Ribble Valley Borough Council

Date: 8th June 2026

Address: Land South of Accrington Road Whalley

Proposal: Approval of details reserved by conditions 6 (site access and off-site works of highway mitigation) and 11 (detailed specifications for the construction of the car park) of planning permission 3/2022/1158.

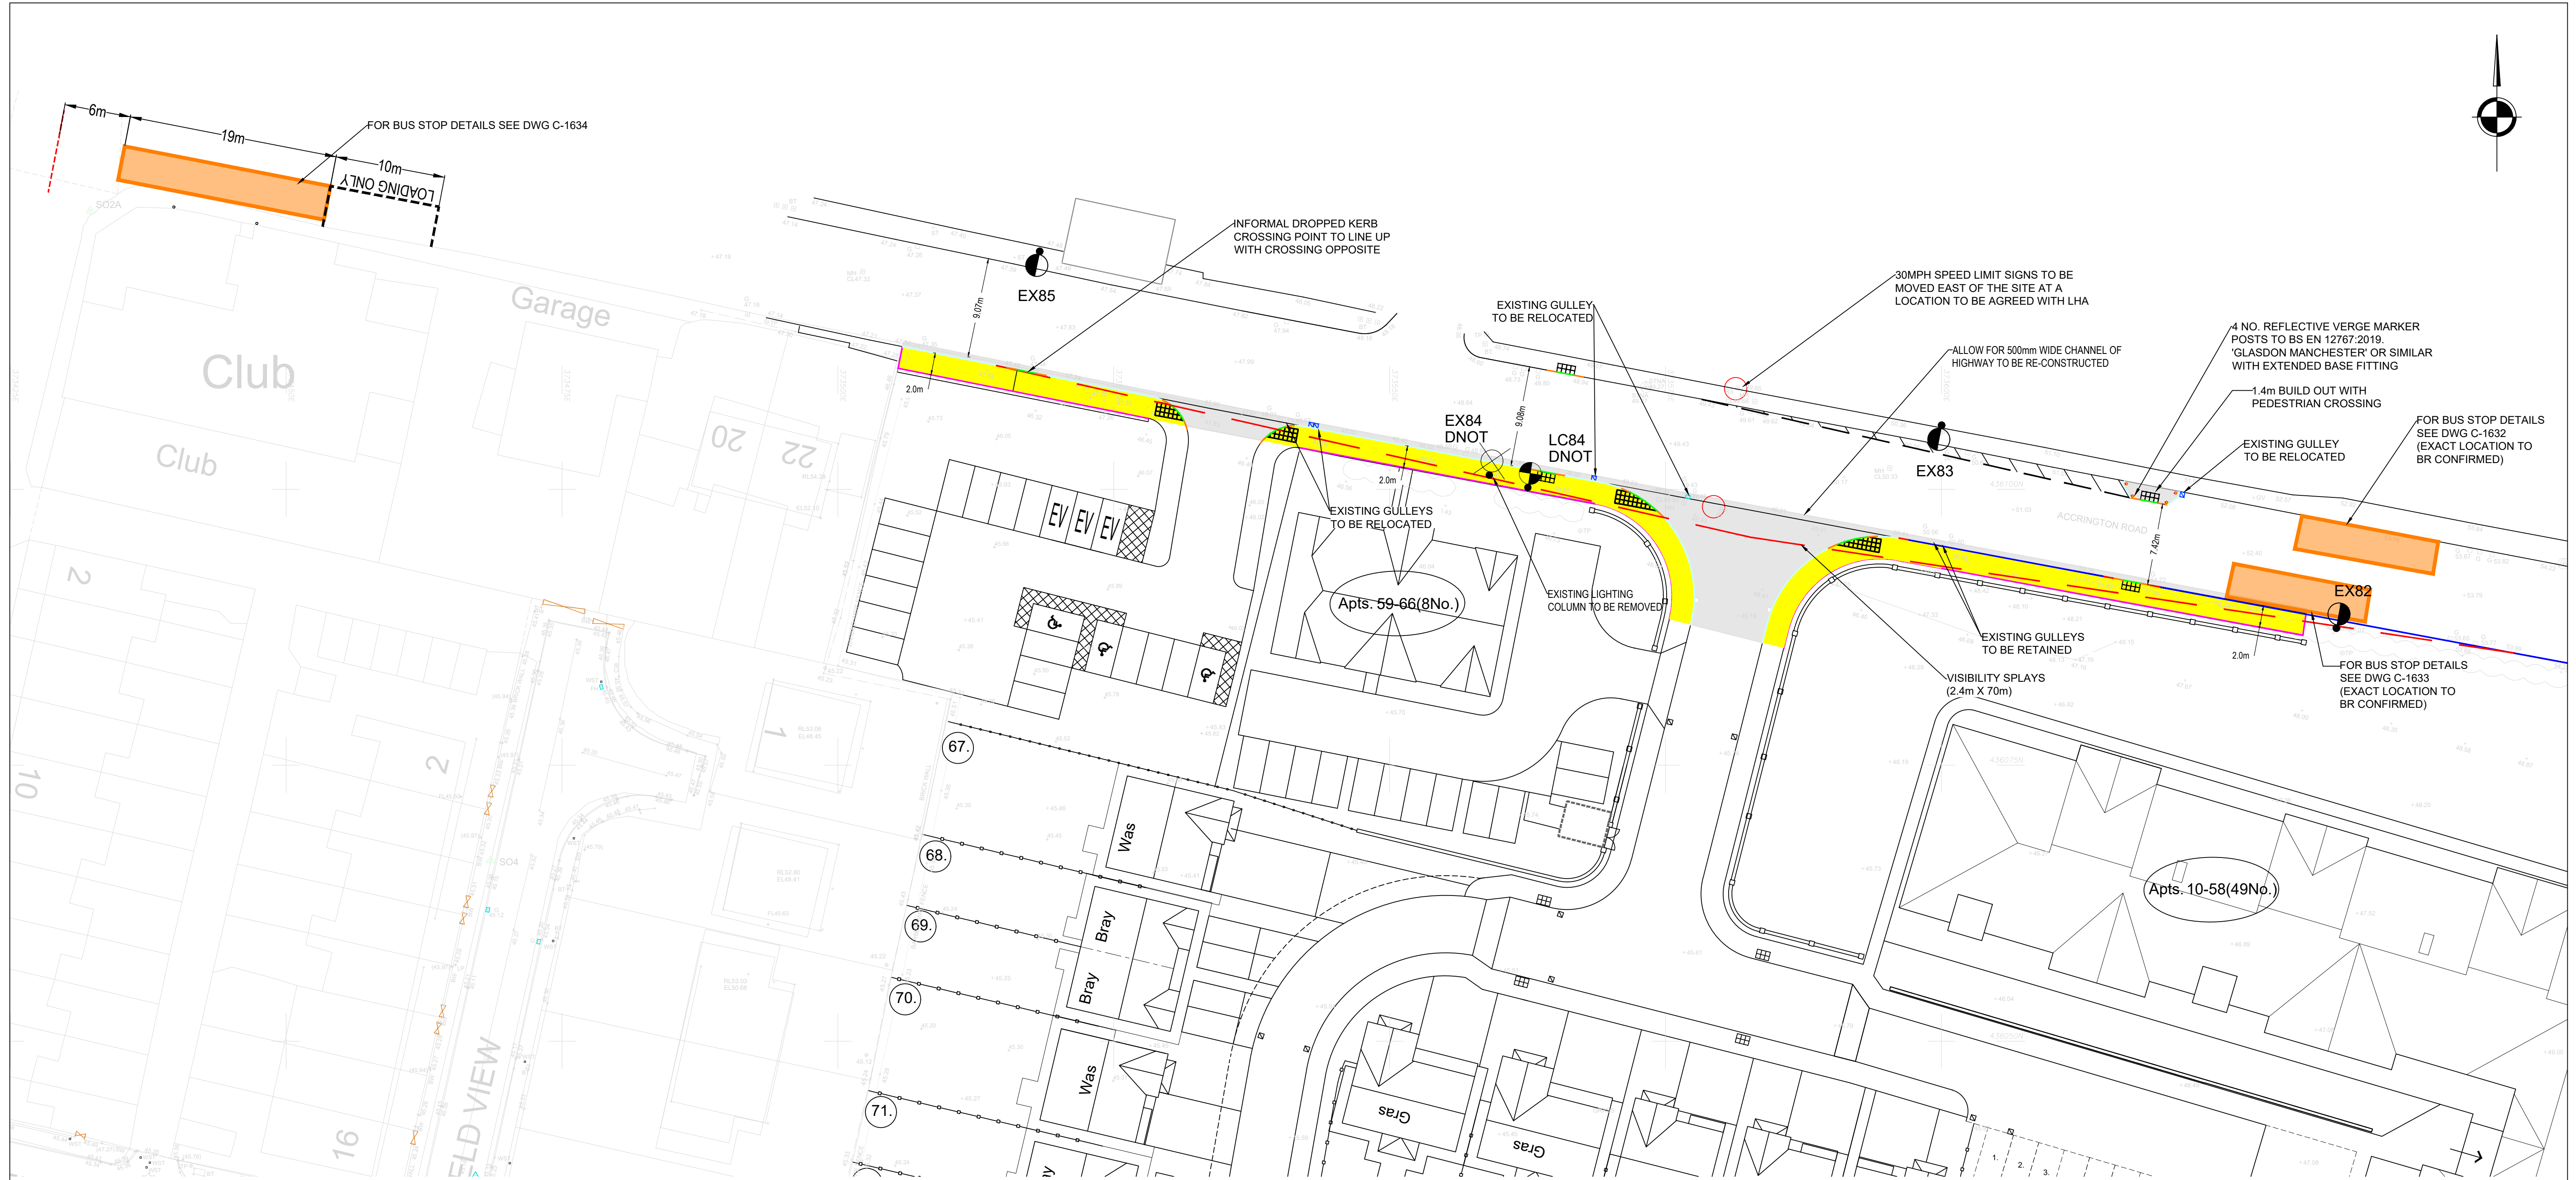
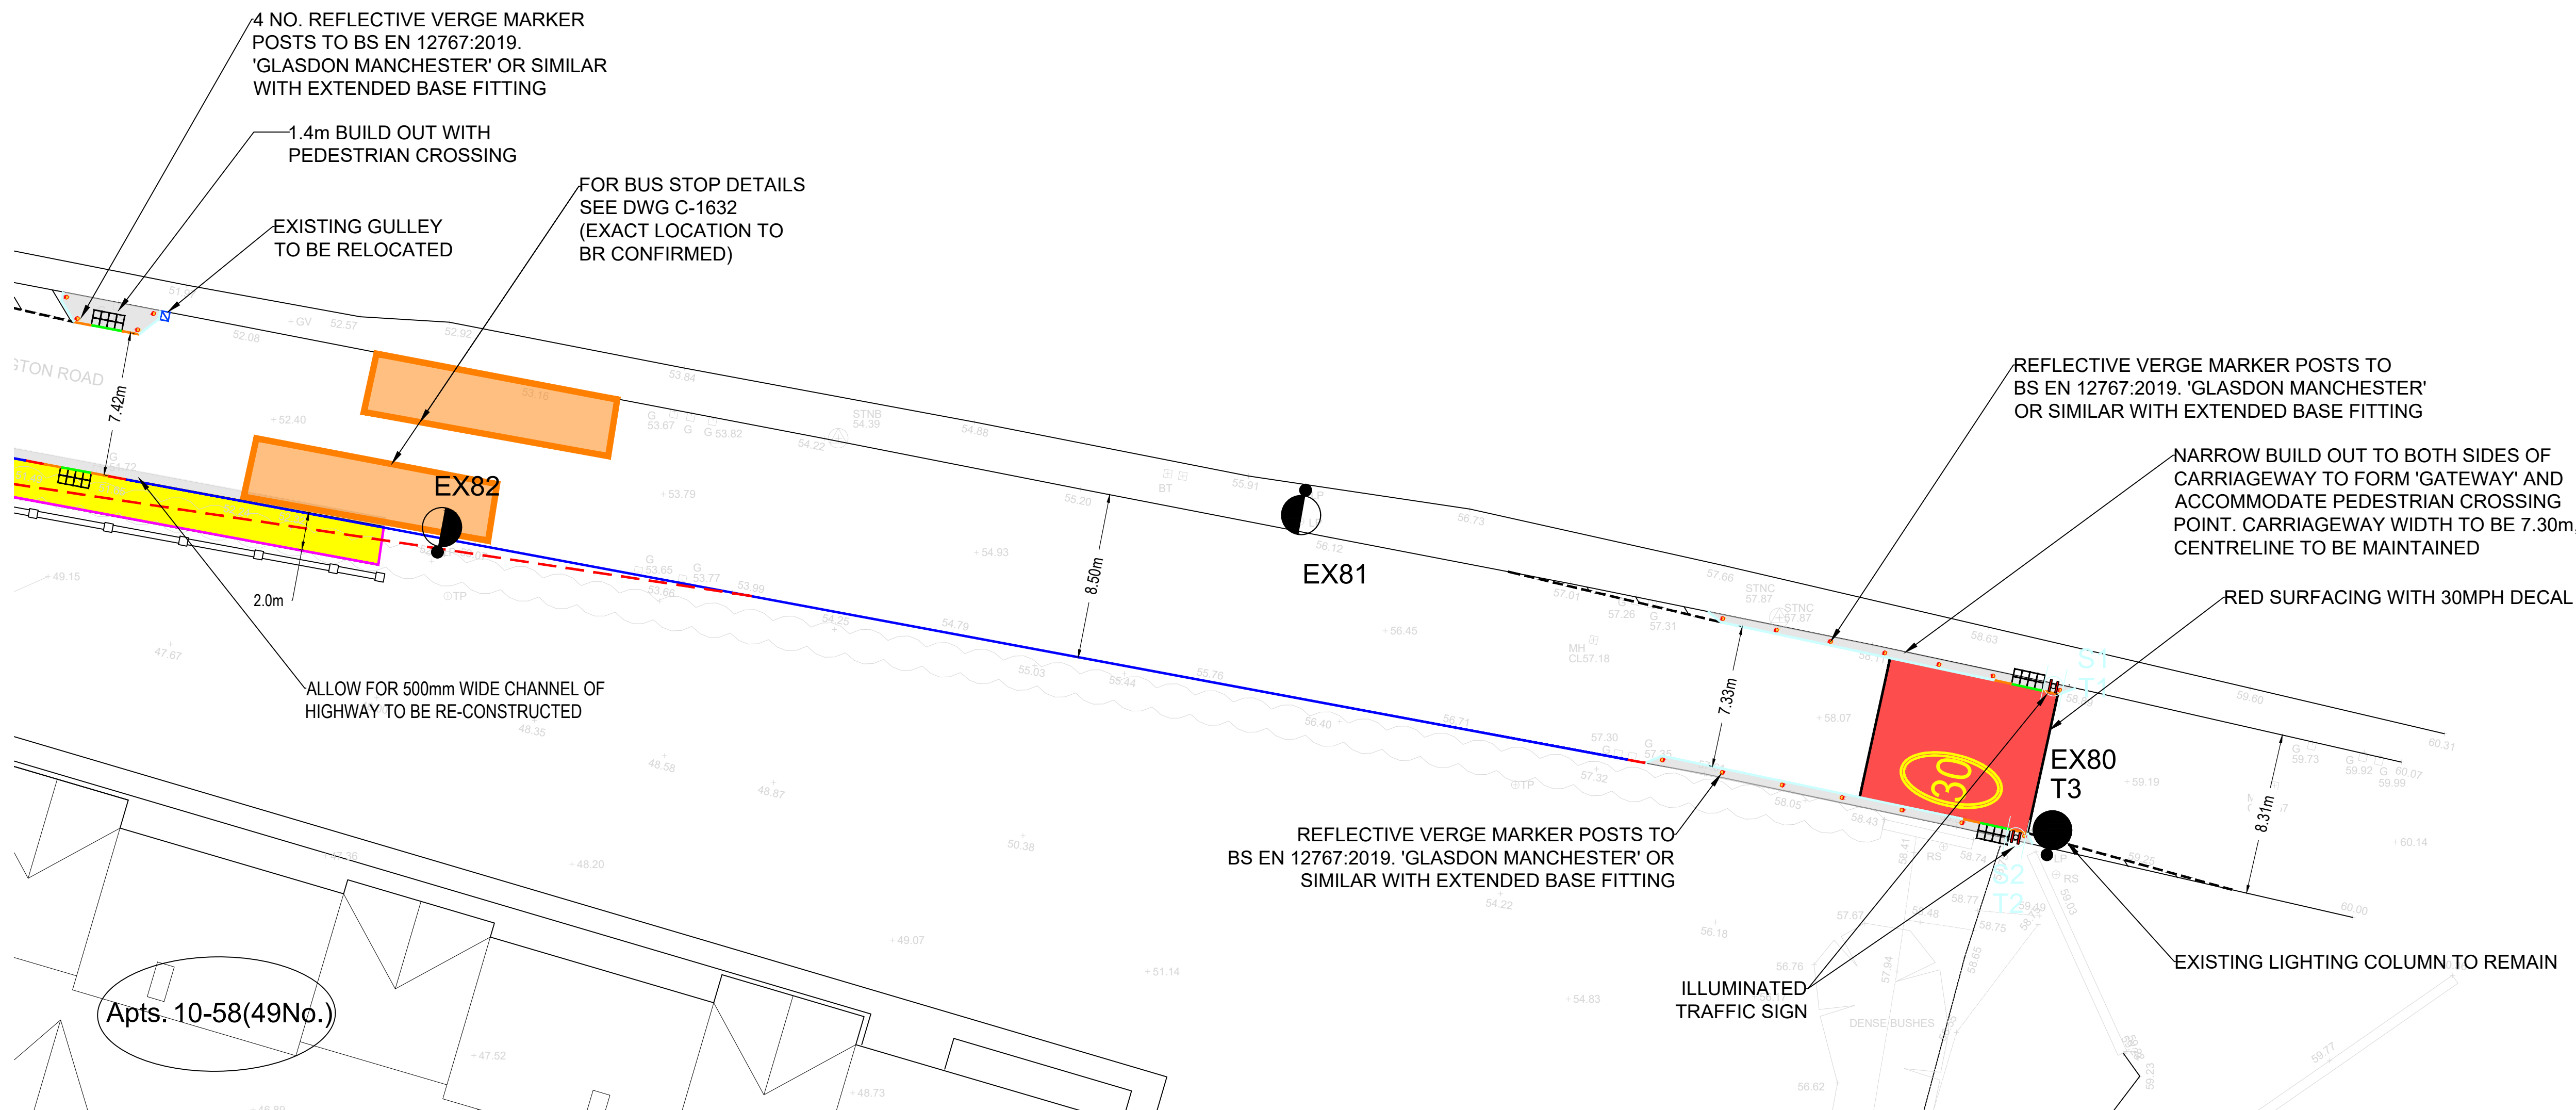
There is one element missing from the scheme of works:- *Uncontrolled pedestrian crossing to the west of the Public Car Park junction which will connect to the existing dropped kerb provided where the existing eastbound bus stop is located.*

TITLE: S278 LAND PLAN

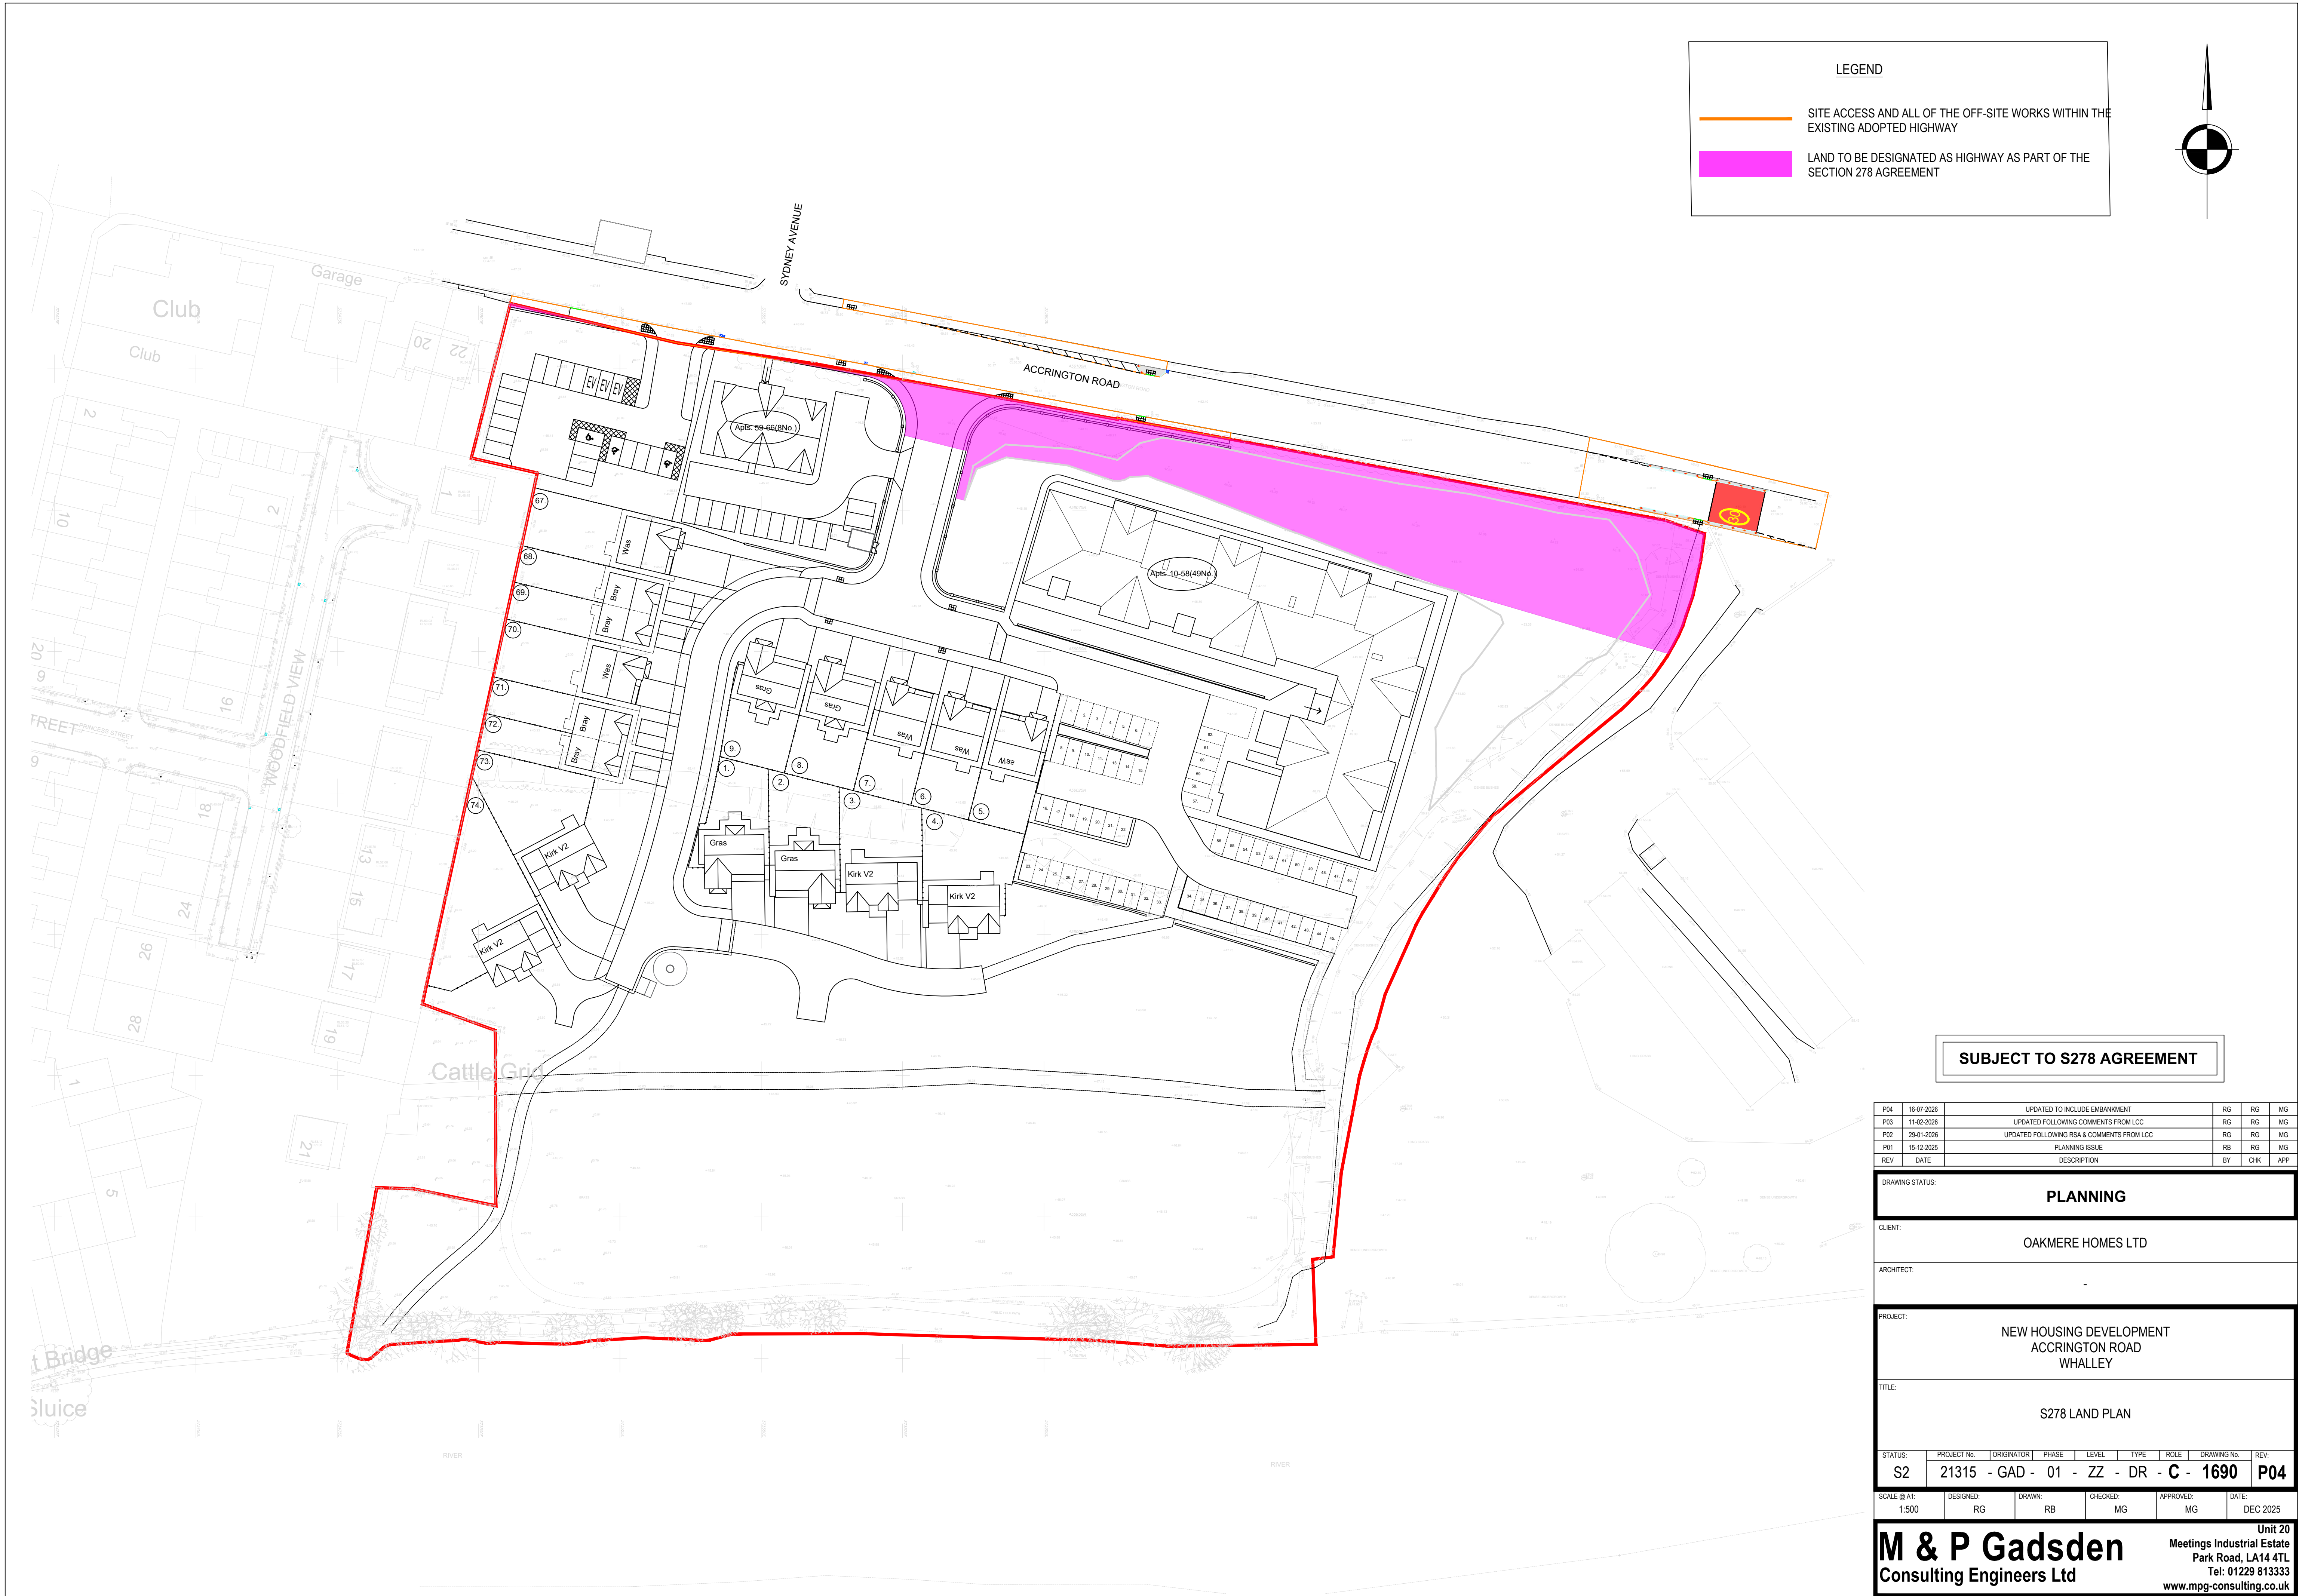
There is also discussion progressing regarding the embankment supporting the highway which is yet to be resolved.
